Your Ref :
Our Ref : BN/20/12/NMA

Application for a non-material amendment following a grant of planning permission BN/3/09/ to change location of first floor windows in both East and West End/Side elevations to both terraces (Plots 1, 4, 5 and 8)
Barnham Community Hall, Yapton Road, Barnham,

Drawing Title:
2-Bed Terrace Cottages

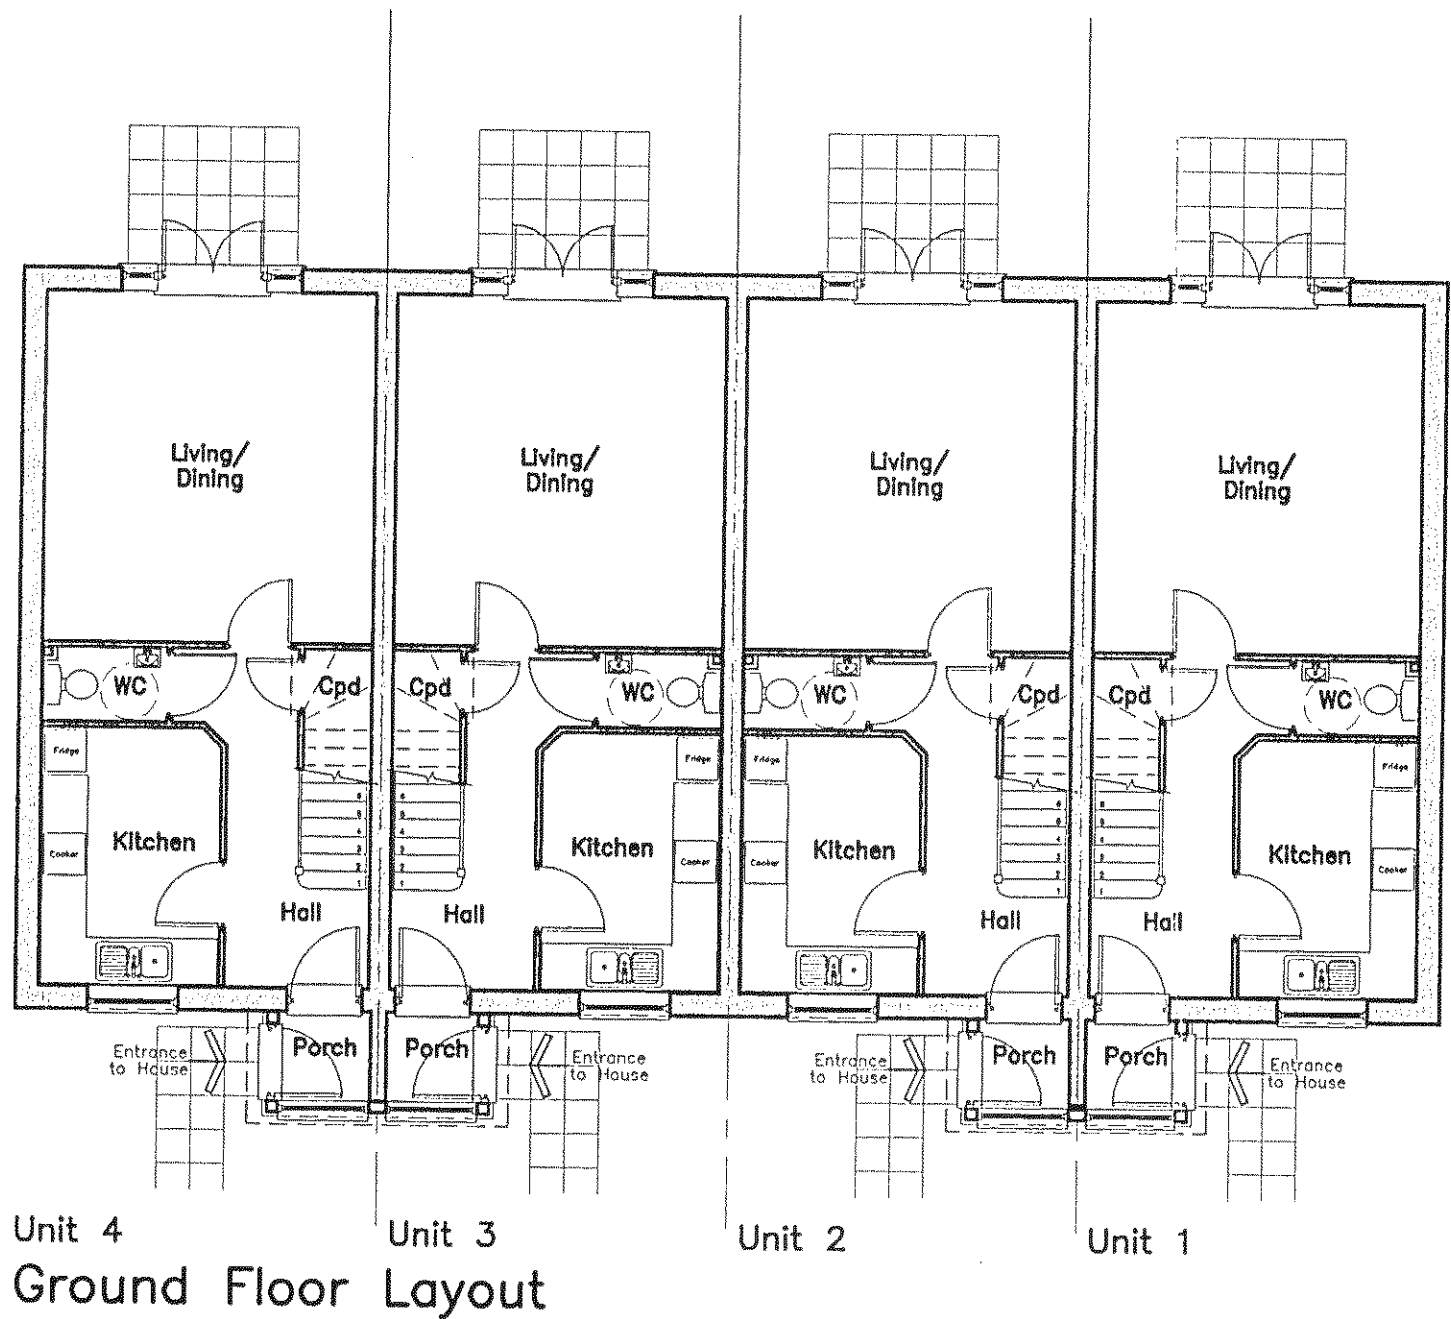
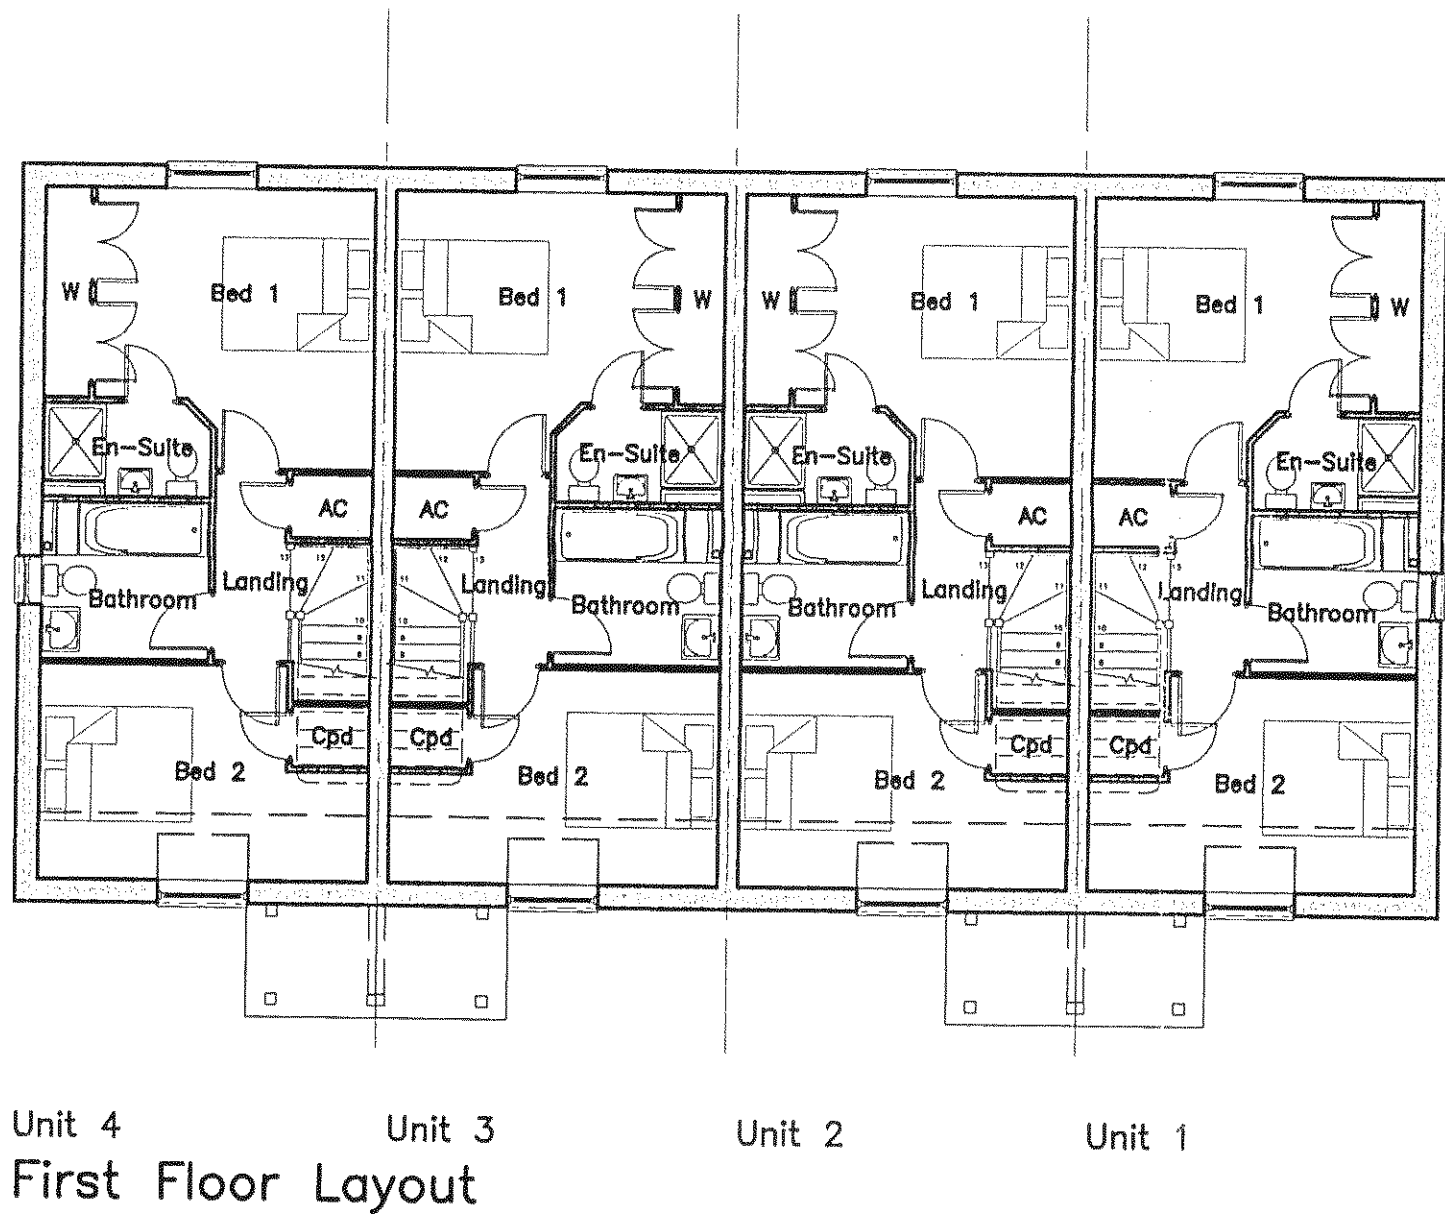
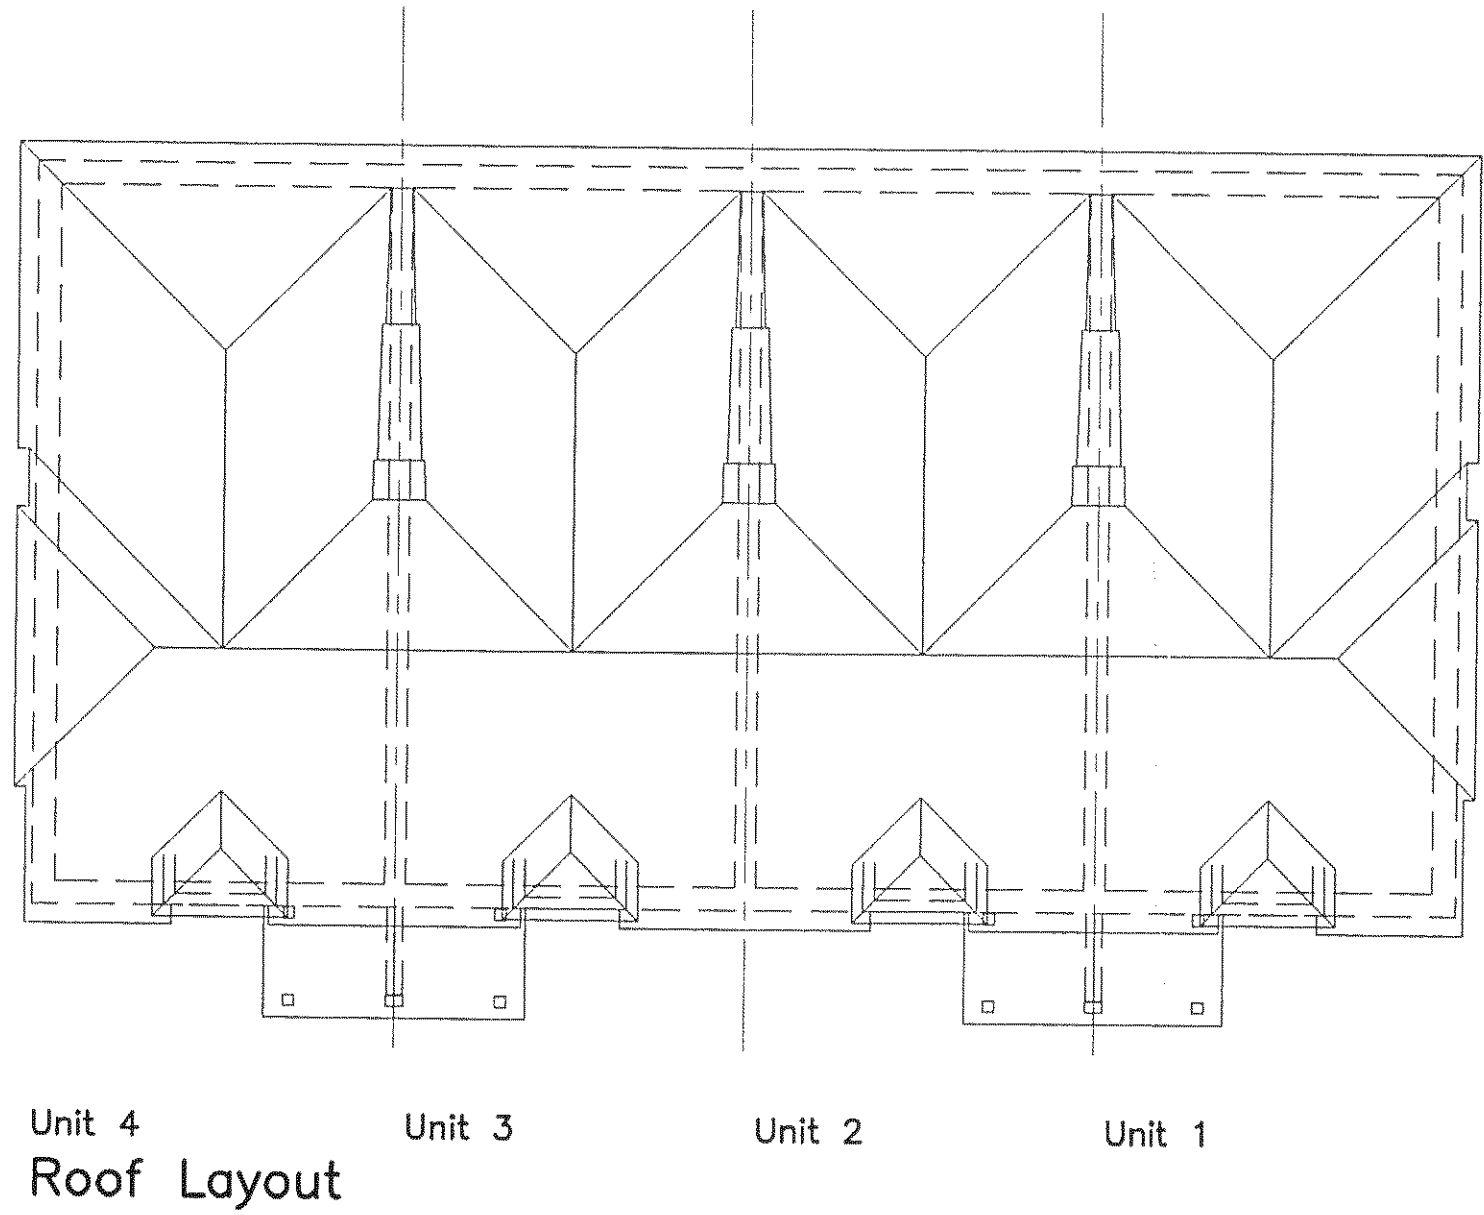
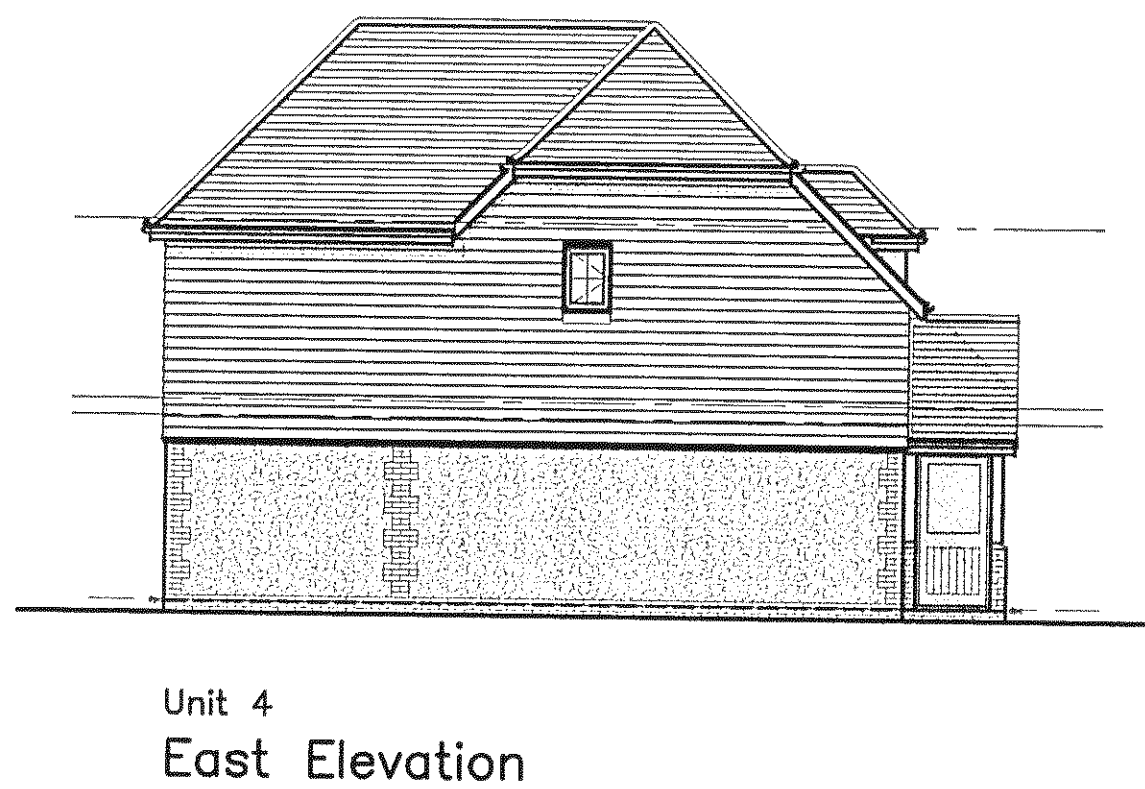
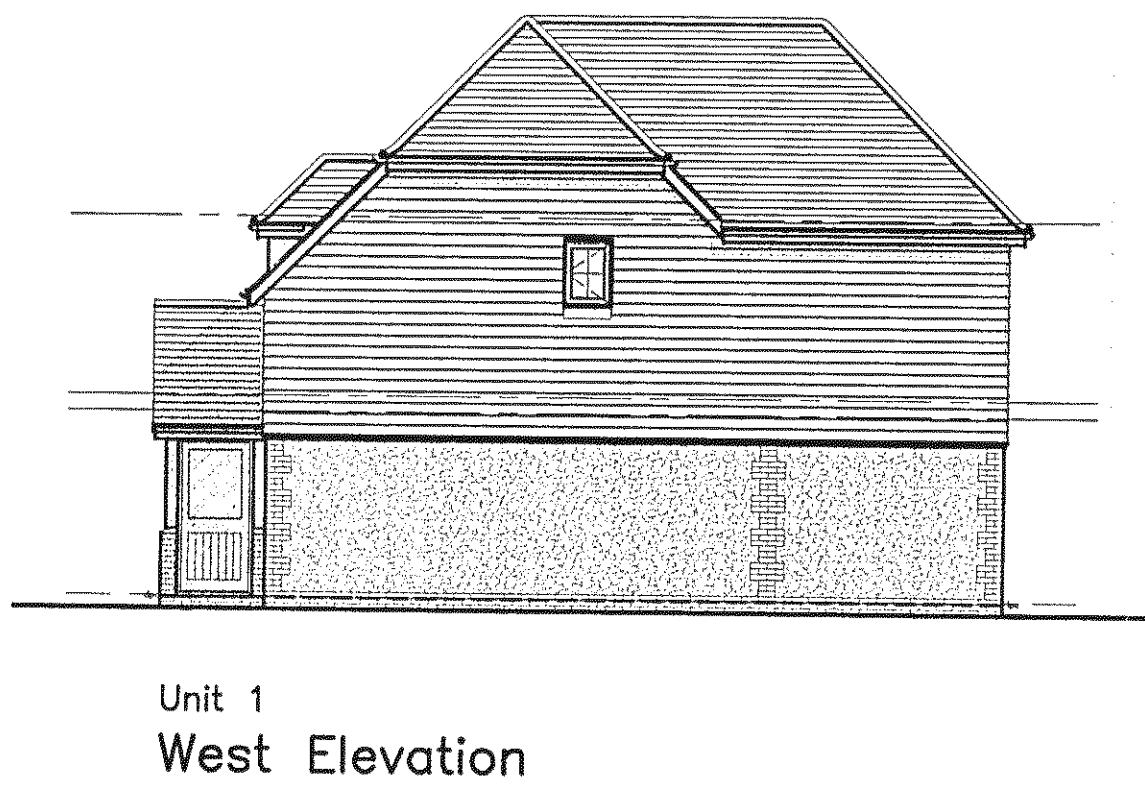
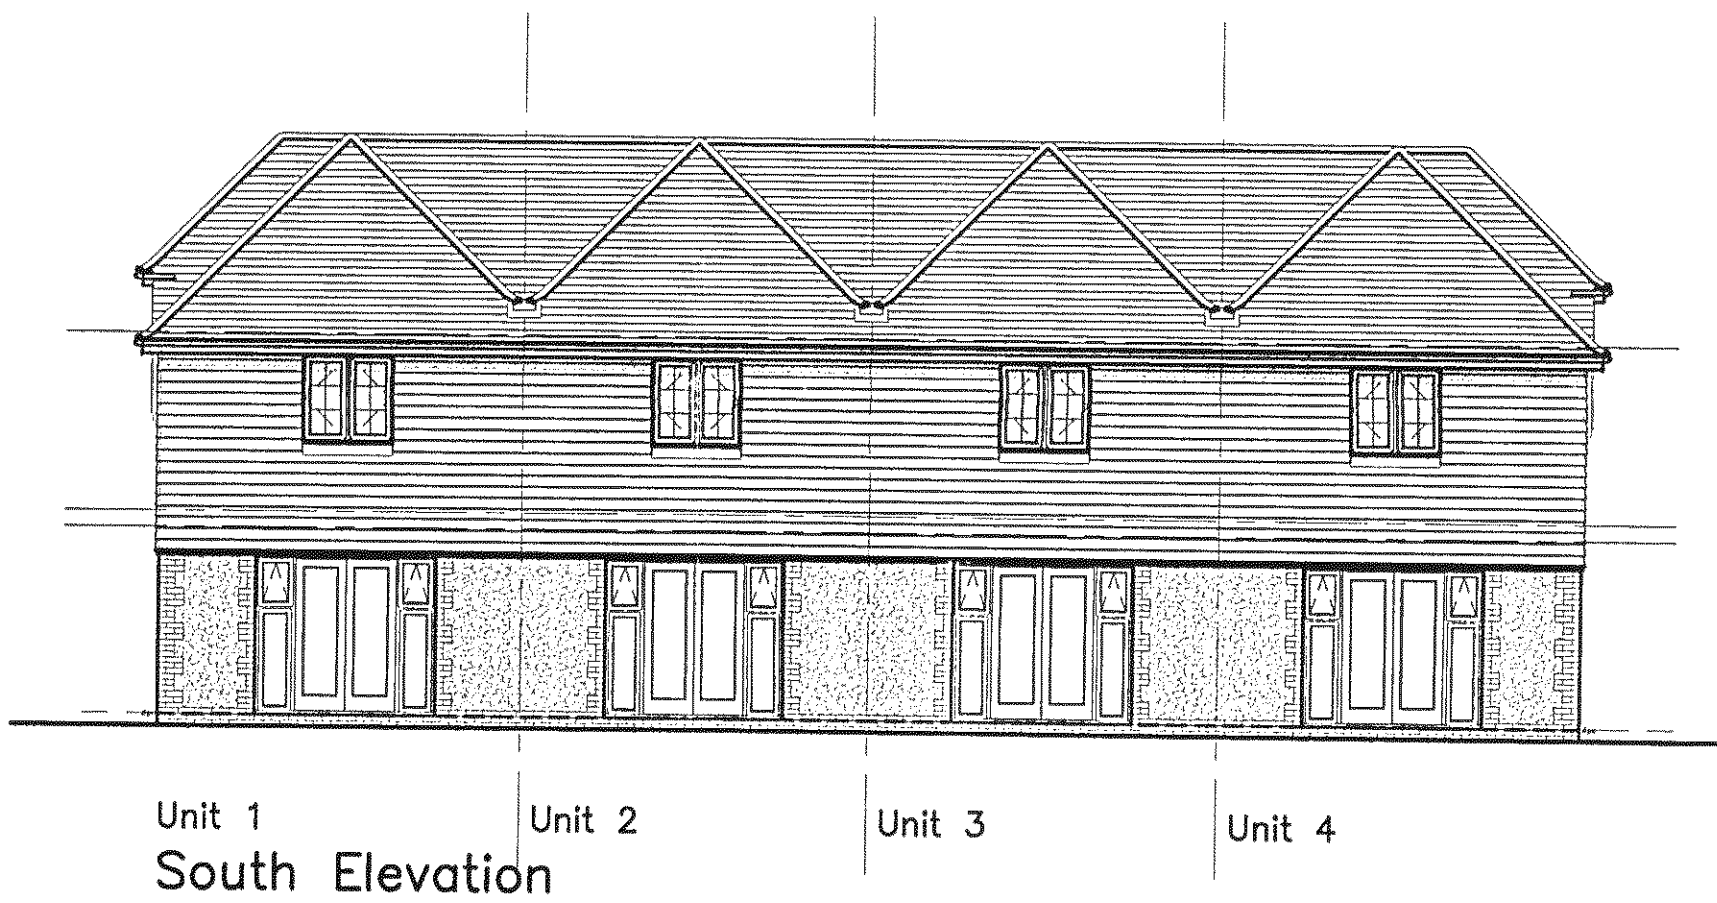
I refer to your recent application for a Non Material Minor Amendment. From the information submitted I am happy to take the alterations as a Minor Amendment to BN/3/09. The first floor window on the west and east elevations of the 2 bedroom houses as shown on drawing 02A shall be opaque glazed only. The approved drawings are now 02A and 03A.
